# KITTITAS COUNTY

## DEPARTMENT OF PUBLIC WORKS

SUBJECT: LPF-21-00013 Forest Ridge Phase 3 Plat

**FOREST RIDGE - PHASE III
PERFORMANCE BASED CLUSTER PLAT
A PORTION OF SECTION 24, TOWNSHIP 20 N., RANGE 15 E.
KITITITAS COUNTY, WASHINGTON**

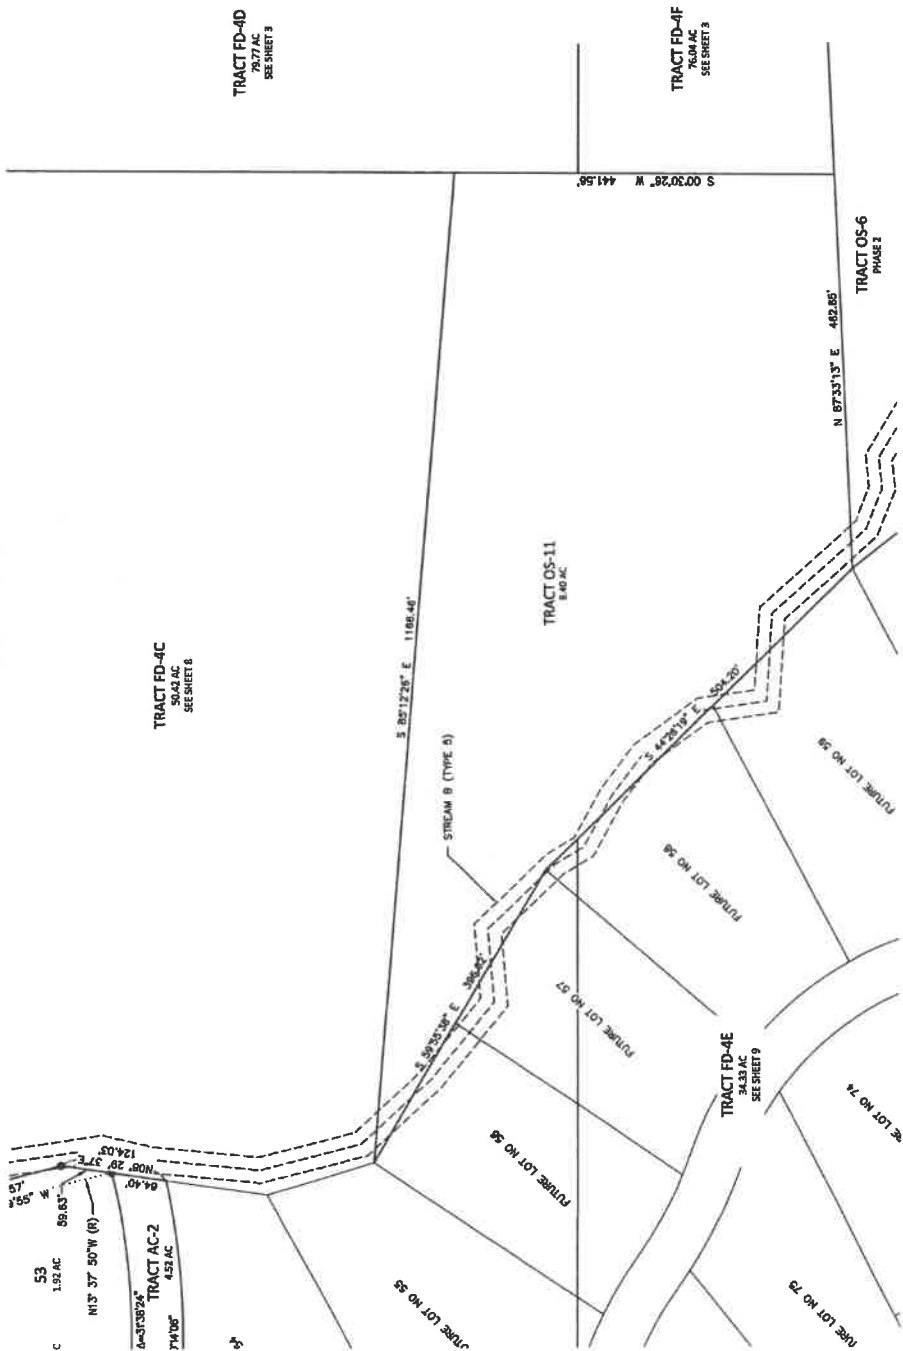
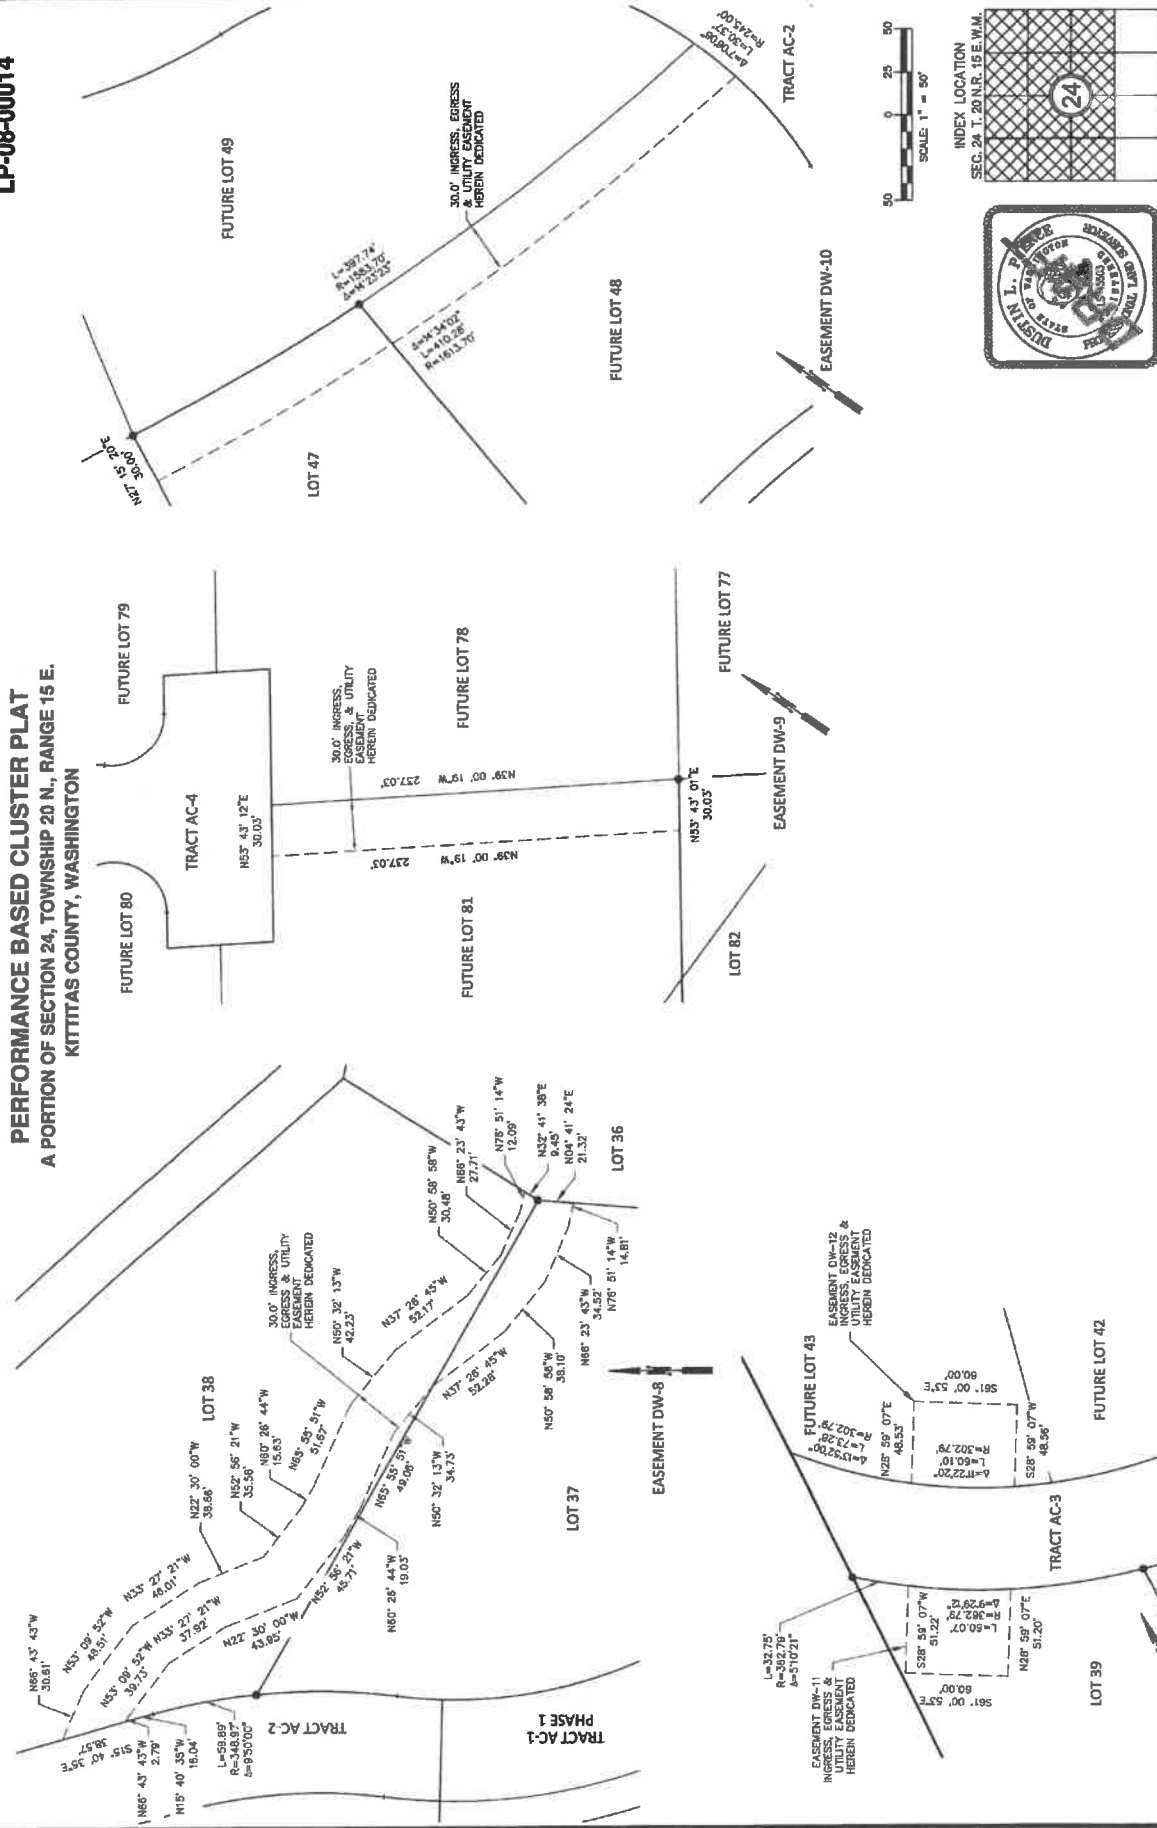
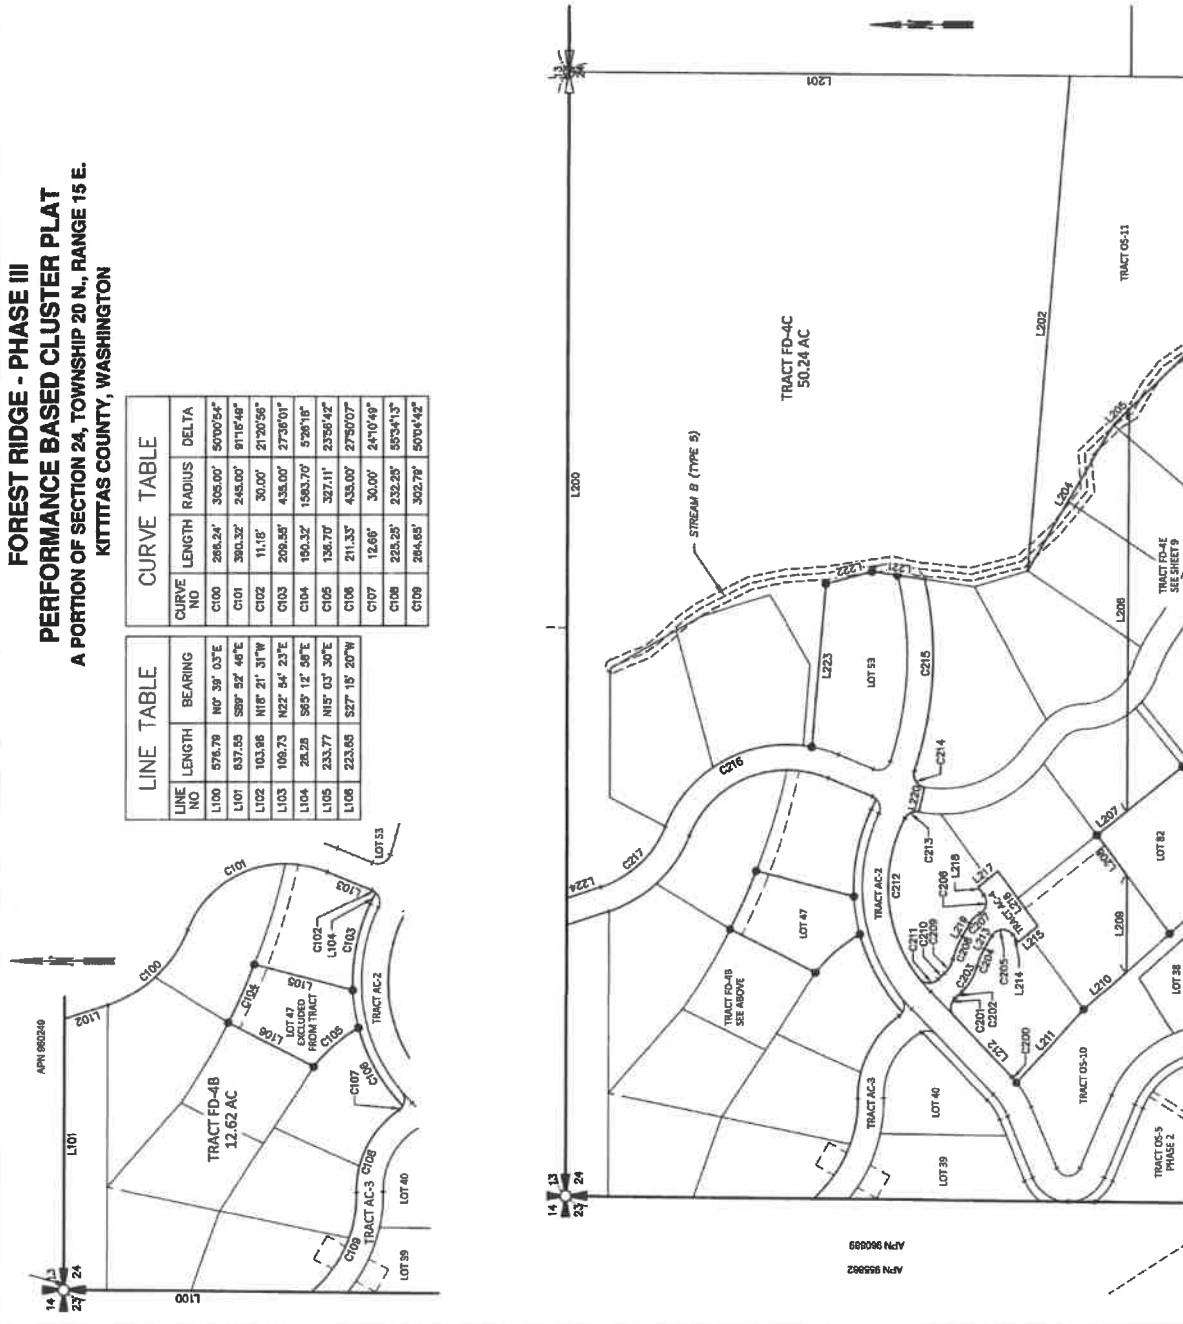
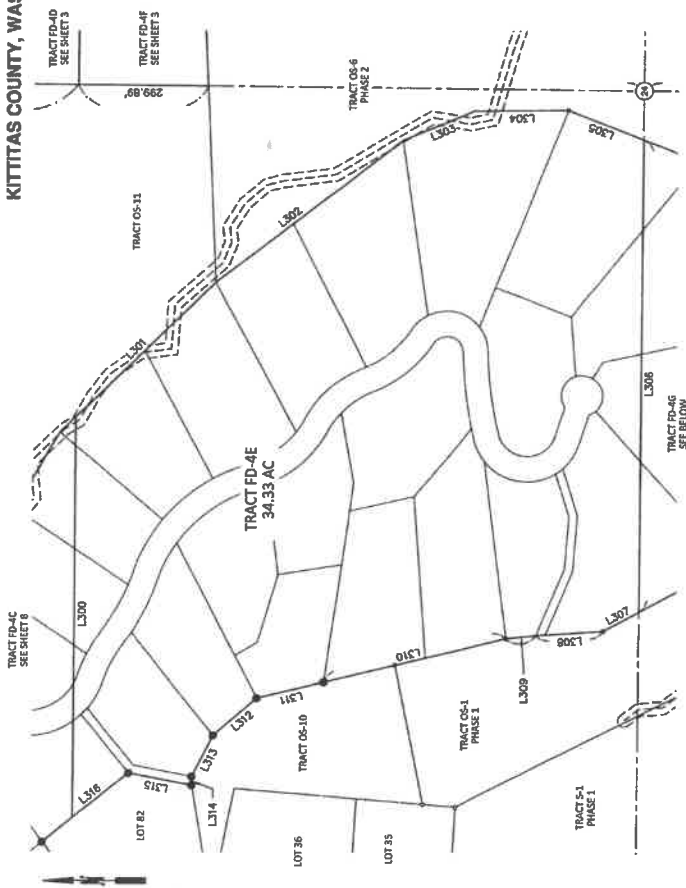
1. Line 310 on Sheet 9 has an erroneous 'crowsfoot'.
2. The East boundary line of Tract FD-4H does not match the closure report by 6" and 0.10 feet.
